Comments for Planning Application DM/2022/01351

Application Number: DM/2022/01351

Address: 10 Briardene Llanfoist Abergavenny Monmouthshire NP7 9LJ

Proposal: Two storey rear extension.

DRG REF 22/HC/100A

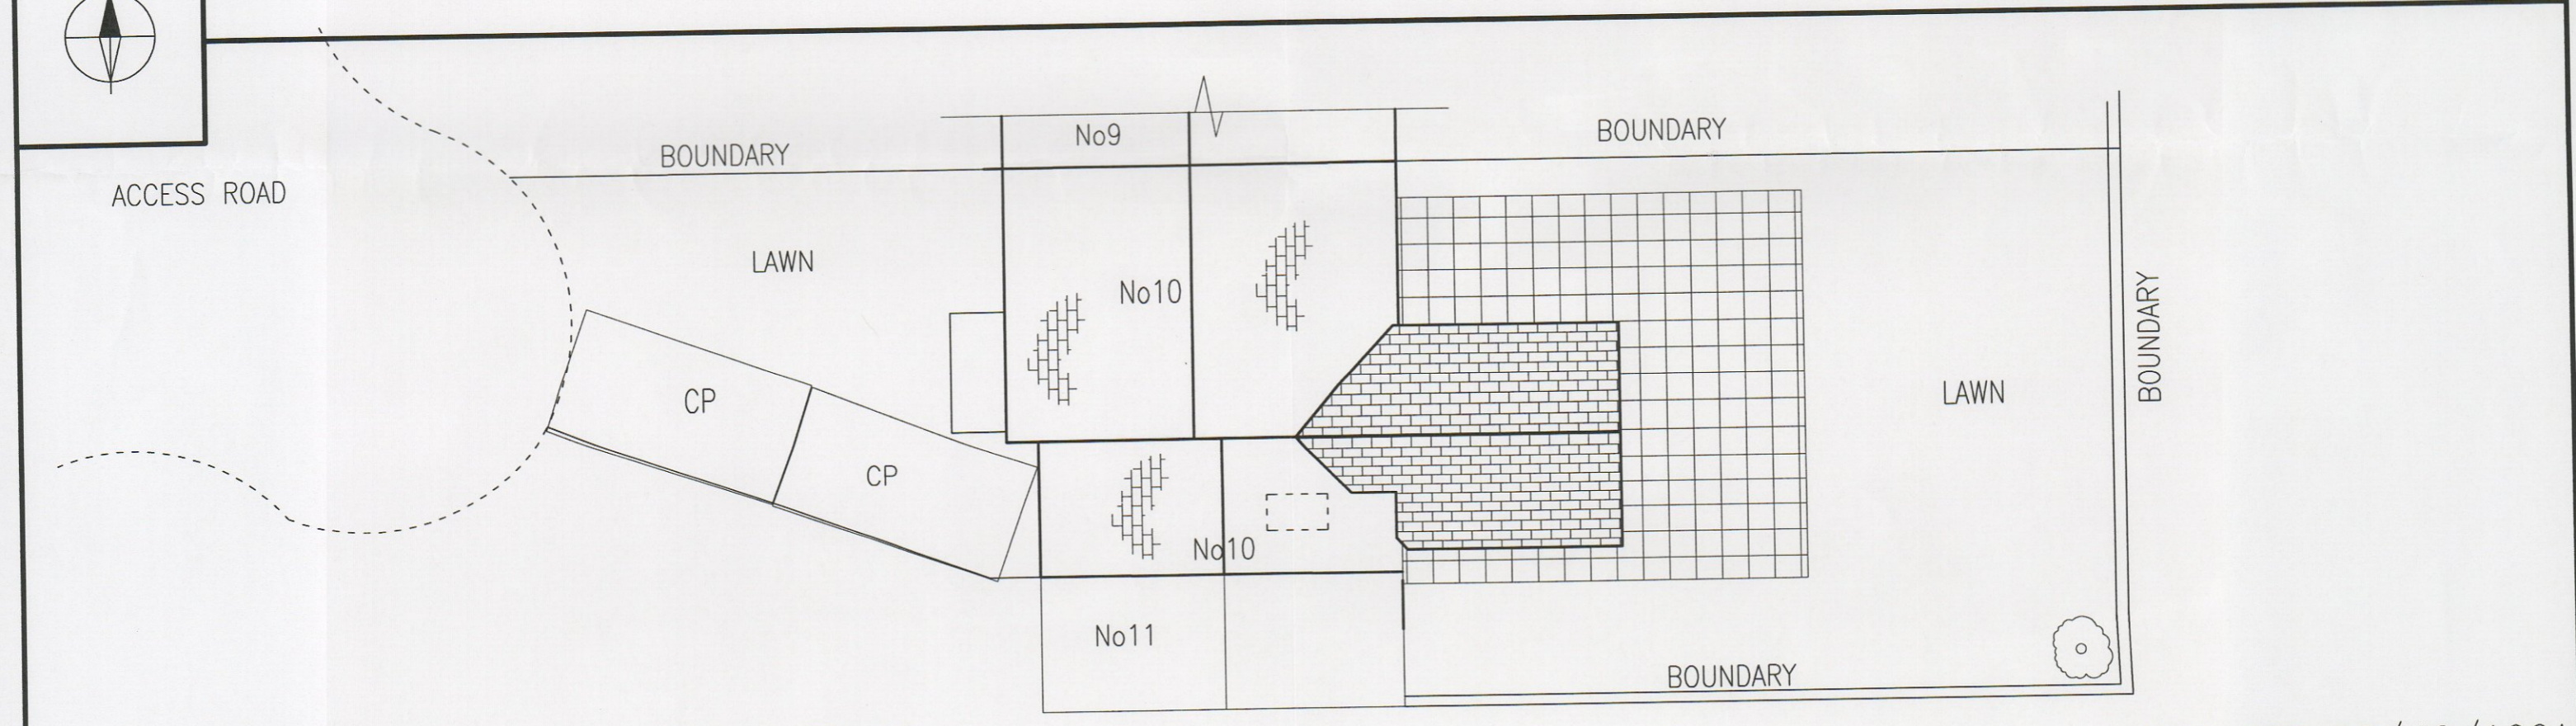
Its length would be approximately half of our garden. We are well aware that there is no such thing as 'a right to a view'. However, the proximity of this two-storey building to our own property would mean that their wall would dominate our view from at least two windows. The plans do not stipulate the distance between our property and the proposed extension. In reality, the new building would be just a few feet from our boundary.

DRG REF 22/HC/102A

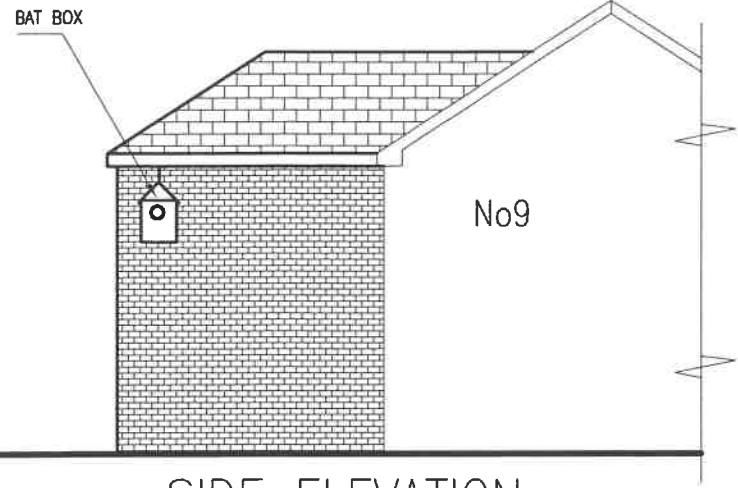
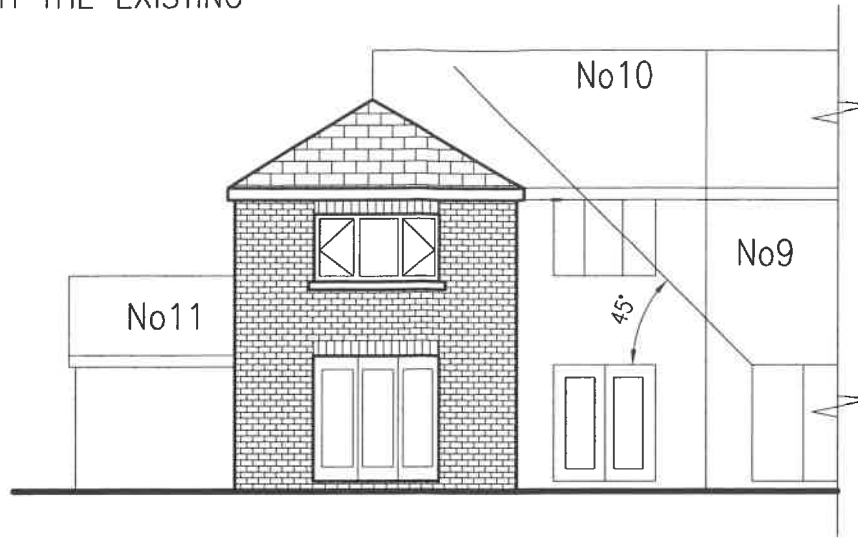
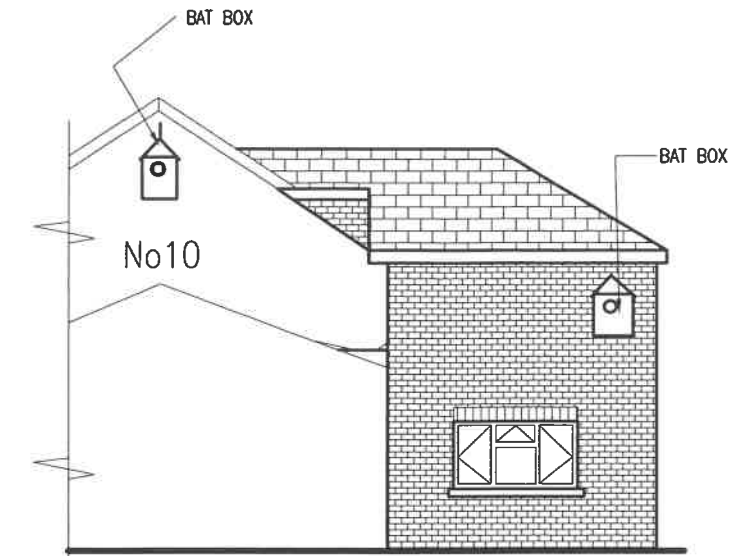
The plans submitted suggest that 'all new rainwater outlets are to pick up with existing at the site'. The guttering for both of our properties culminates in a down-pipe on our property. The assumption here is that we would take responsibility for additional rainwater and the stress that puts existing guttering under.
